ENG-SF21026-R3-Plat.pdf Markup Summary

SEPTEMBER 10, 2021 Sheet 1 of 5
DREXEL, BARRELL & CO.
Engineers • Surveyors
3 SOUTH 7TH STREET
COLORADO SPGS, COLORADO 80905
(719) 260-0887 Fax: (719) 260-8352
Job No. 21187-01 Drawing: 21187-01 WINDERMERE FILING 1 PLAT.dwg

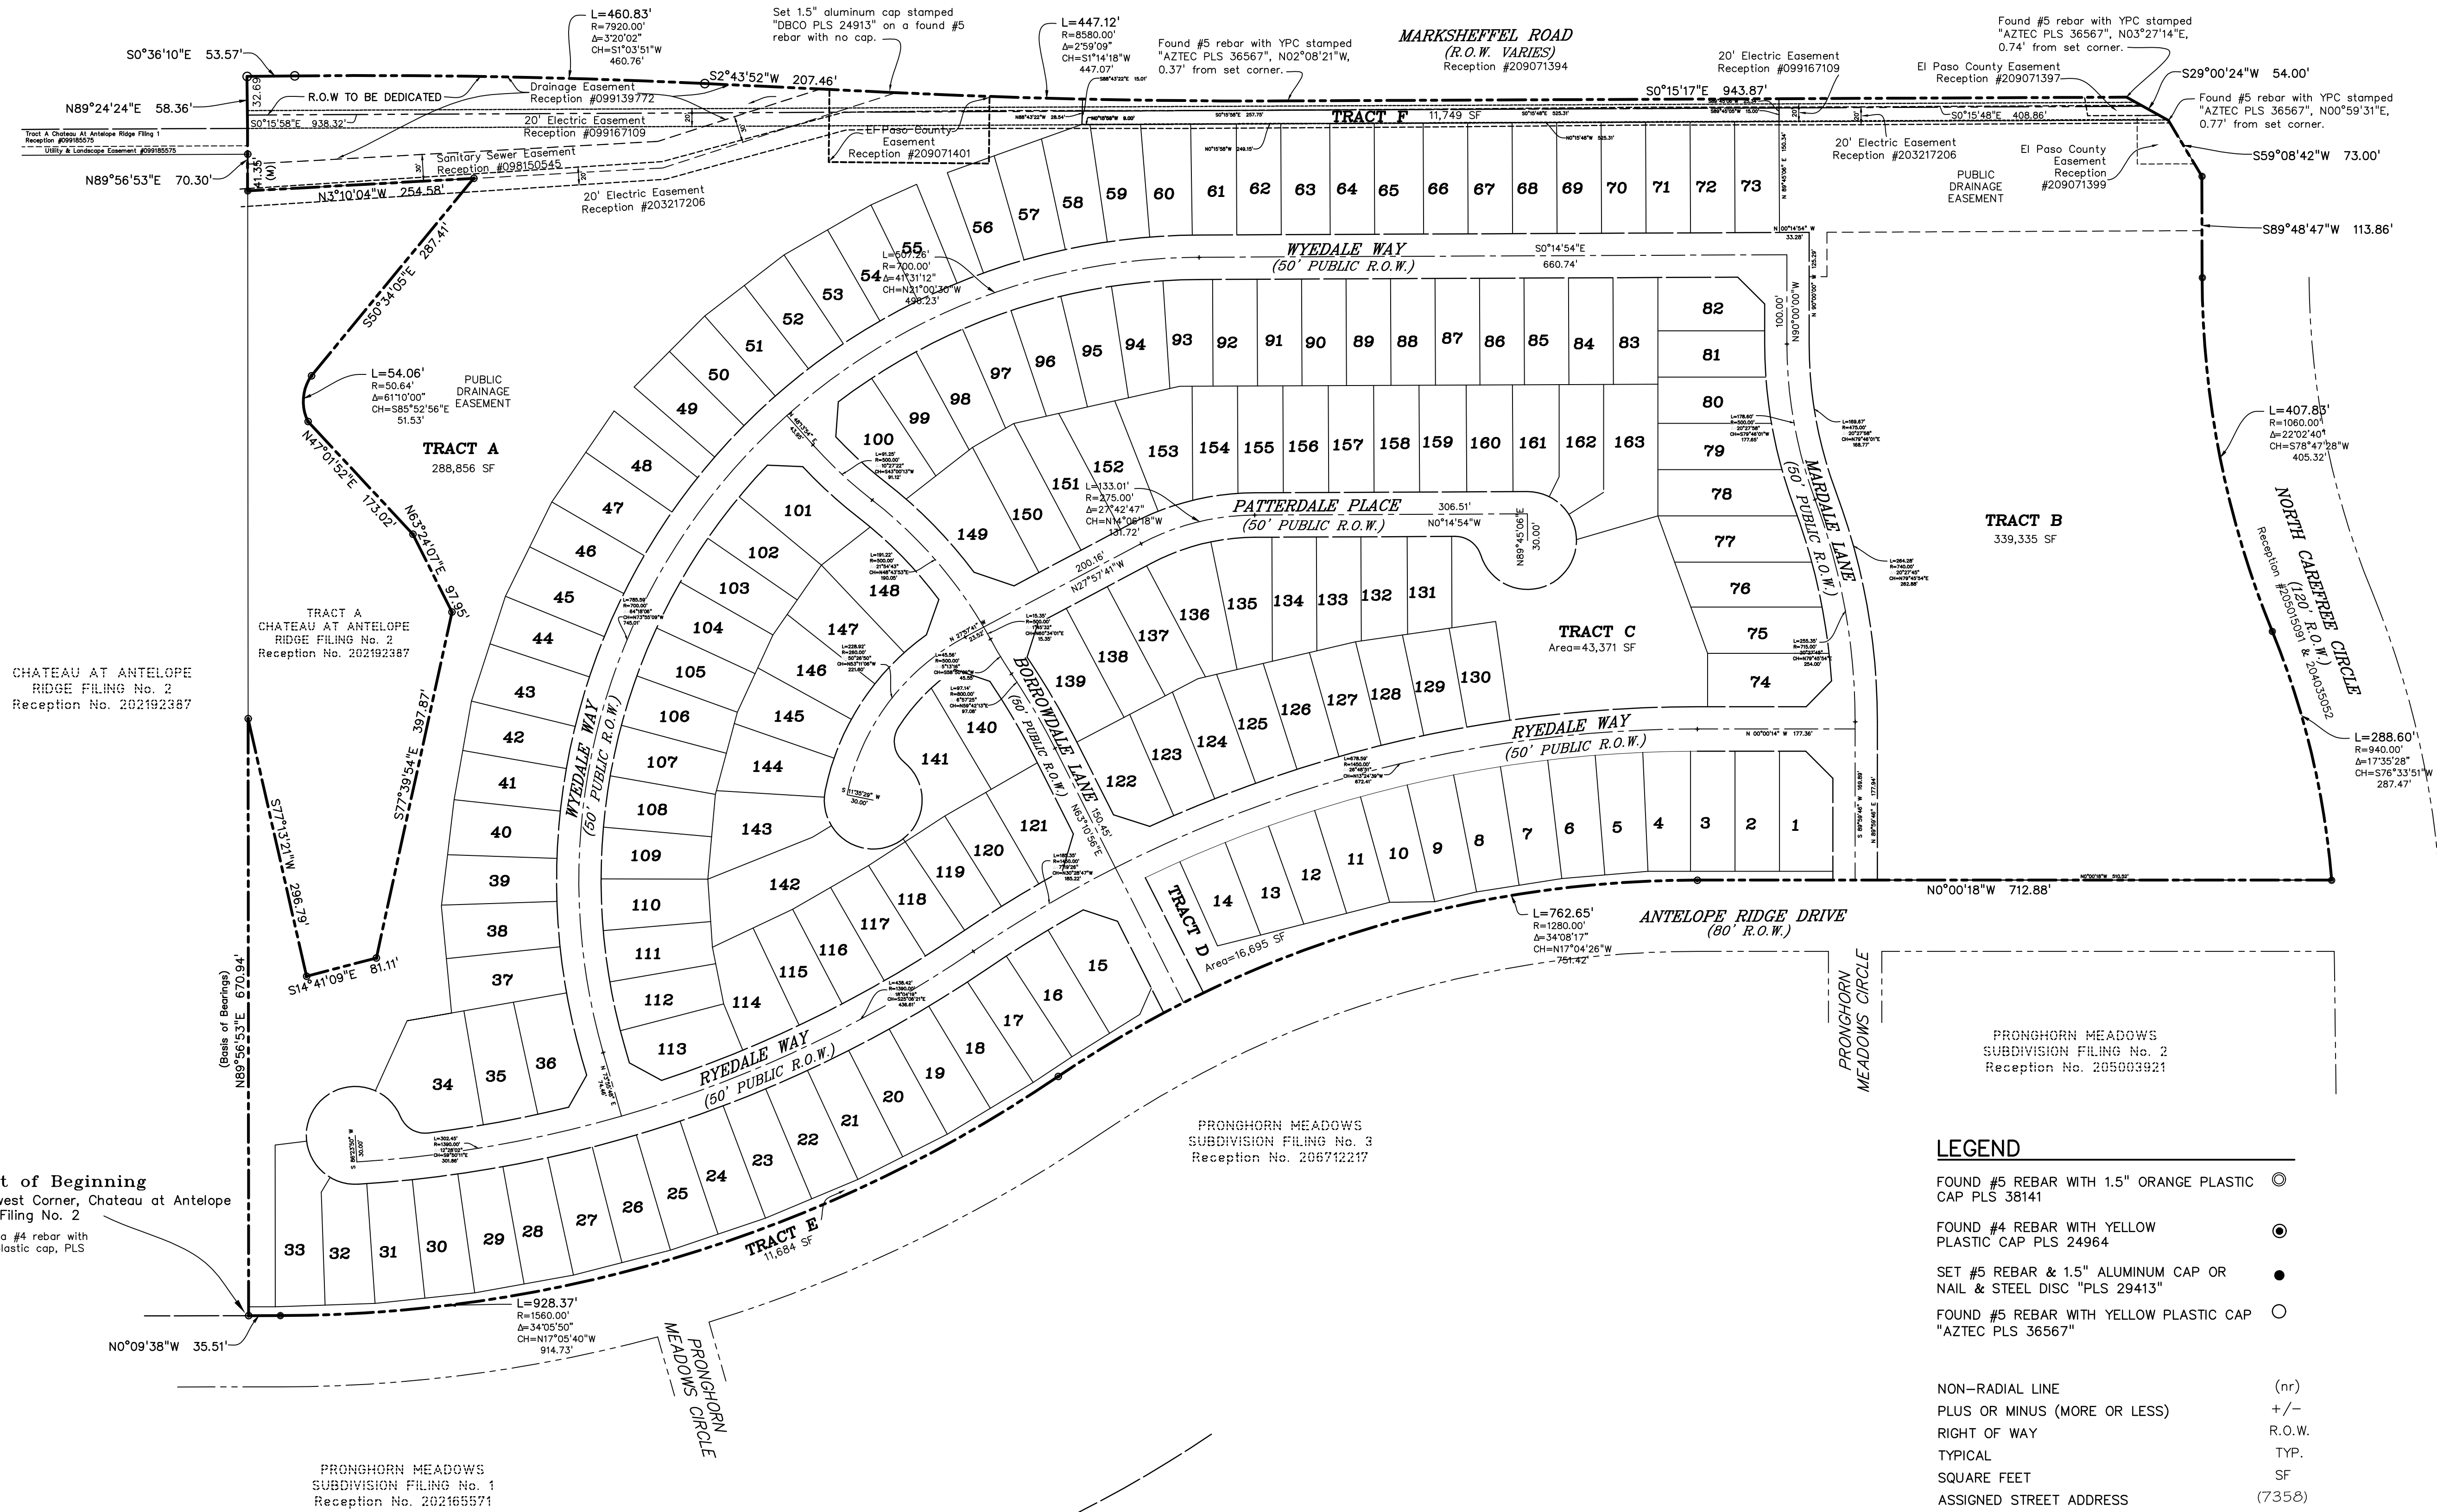
"Pikes Peak Regional Building Enumerations approval provided by email dated _____ and recorded in the El Paso County Clerk and Recorder records at reception number _____"

Is a metro district acceptance block needed?

(for Sands Metro District No. 4 now)

why is this not the metro district?

change to Sands MD #4?

provide

Provide a summary table with number of lots and tracts and total acreages of those and ROW.

WINDERMERE FILING NO.1

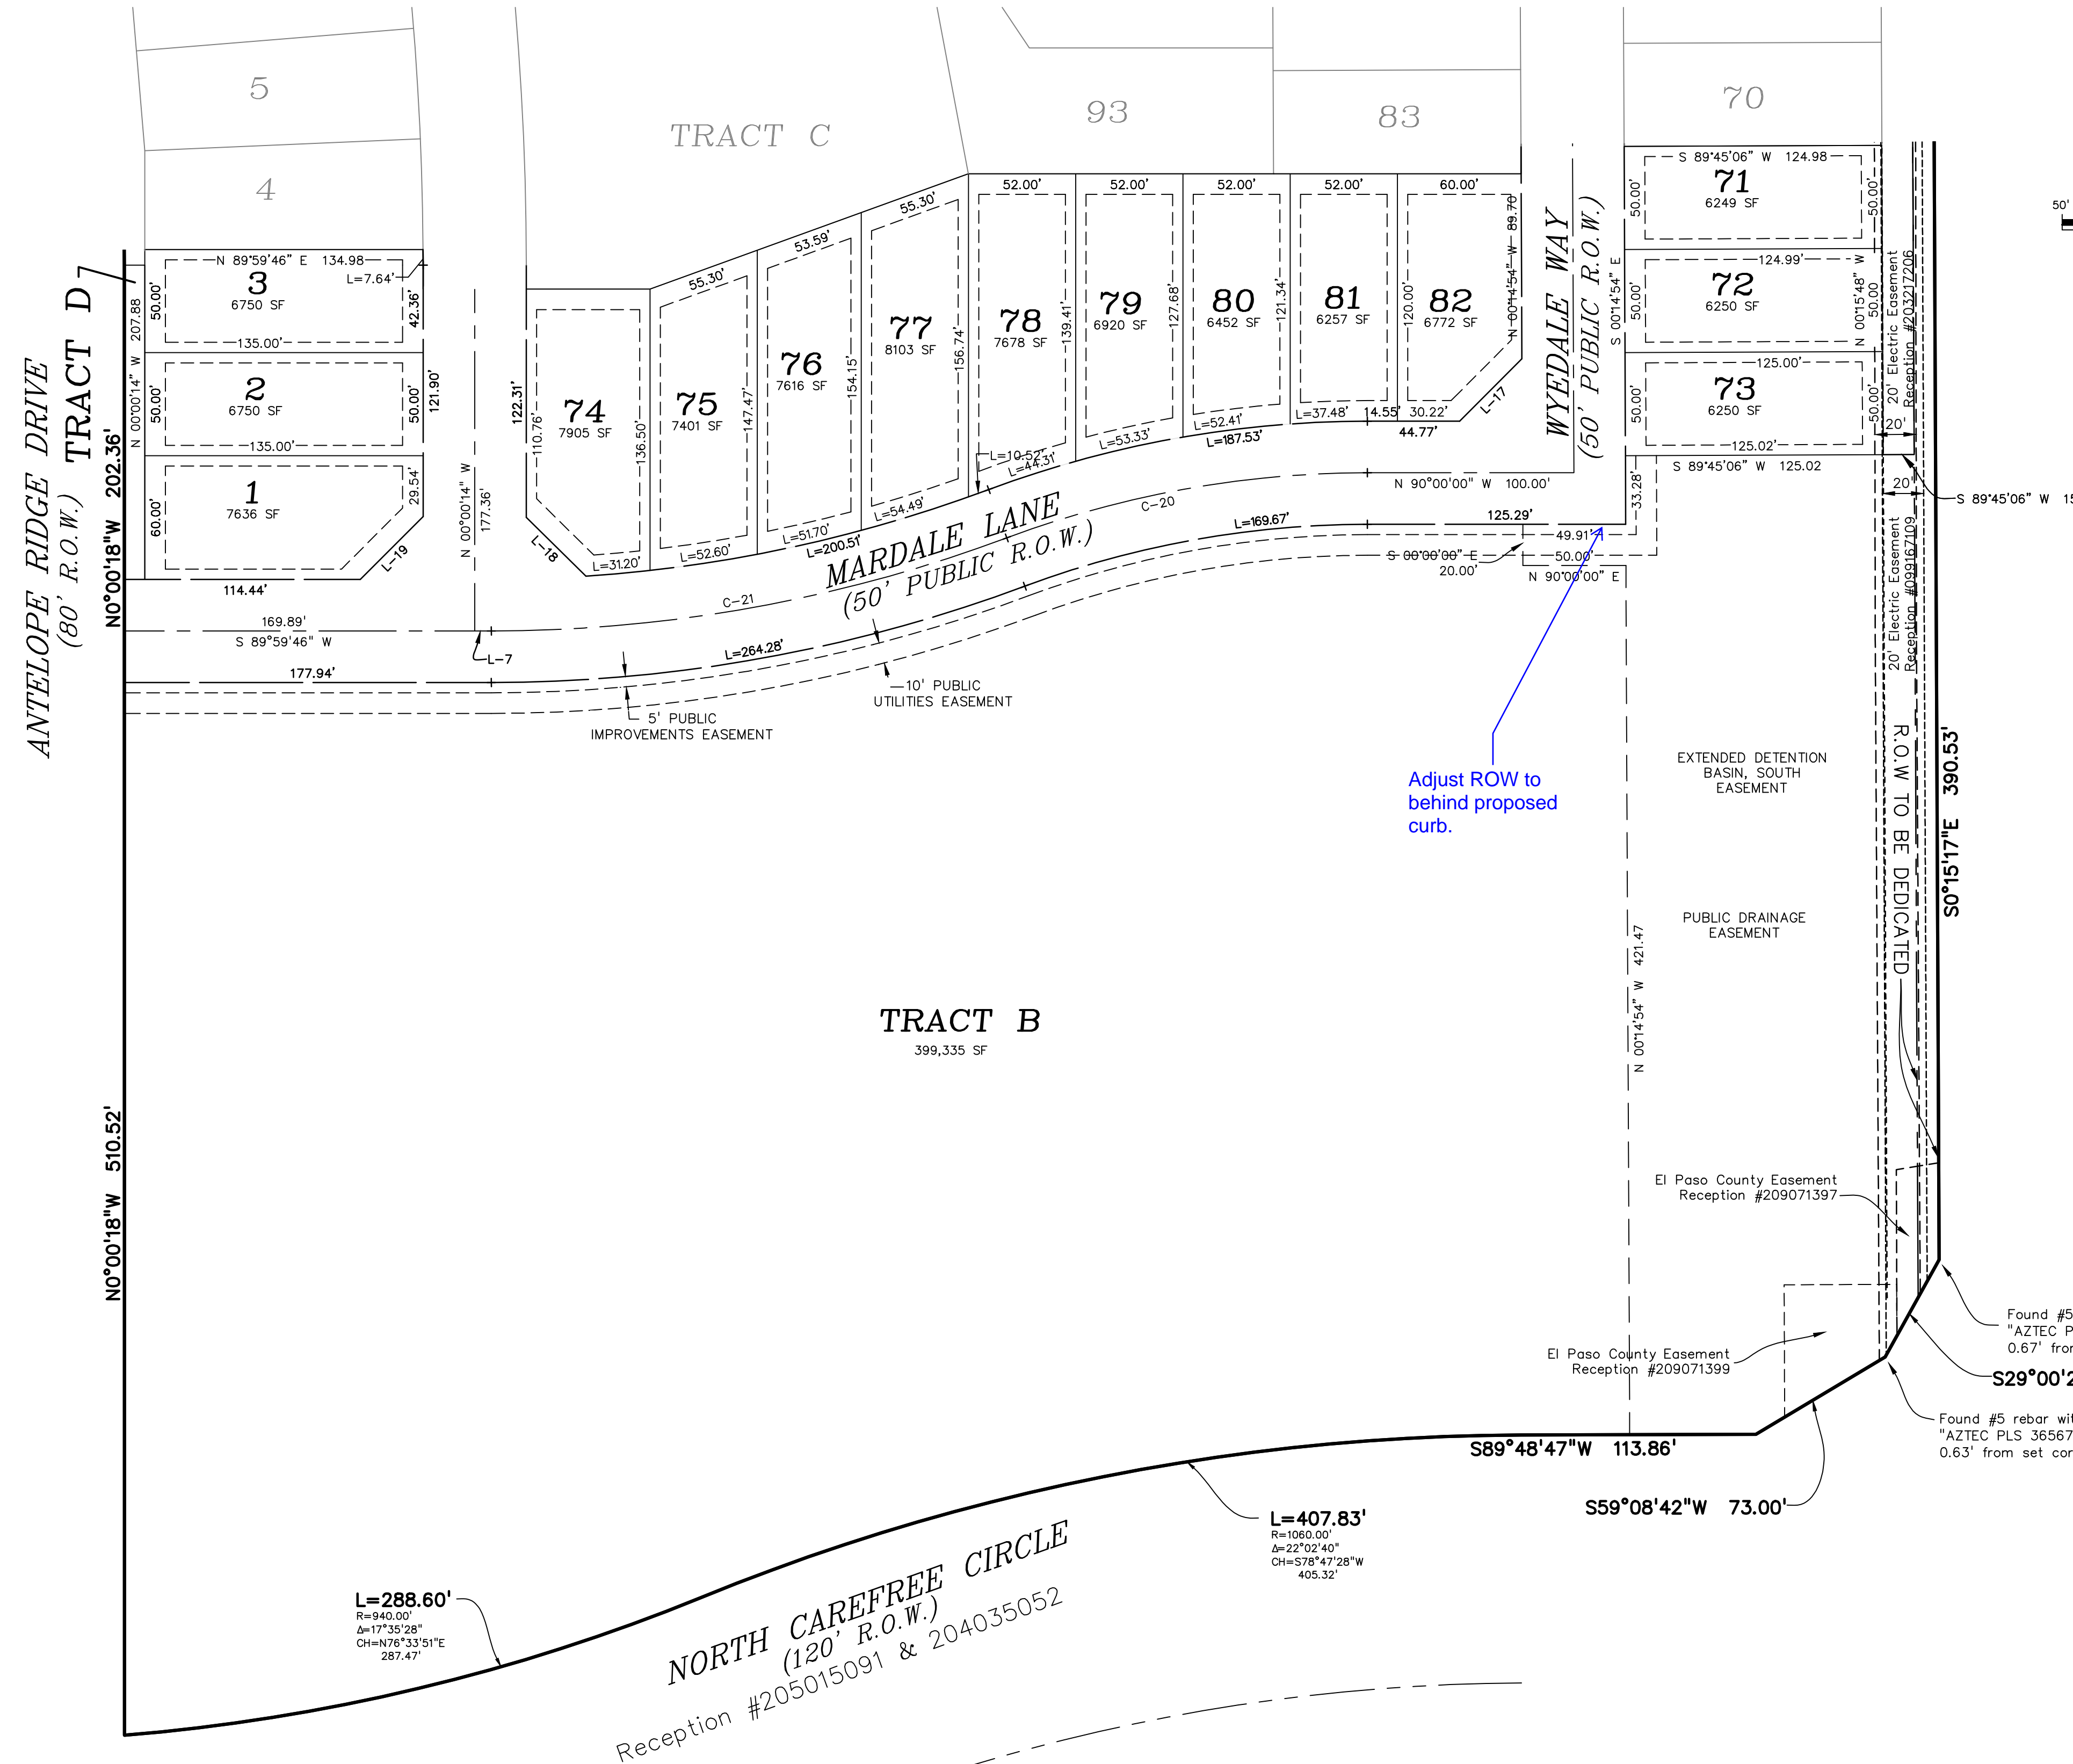
Why are easement lines only shown on these lots?
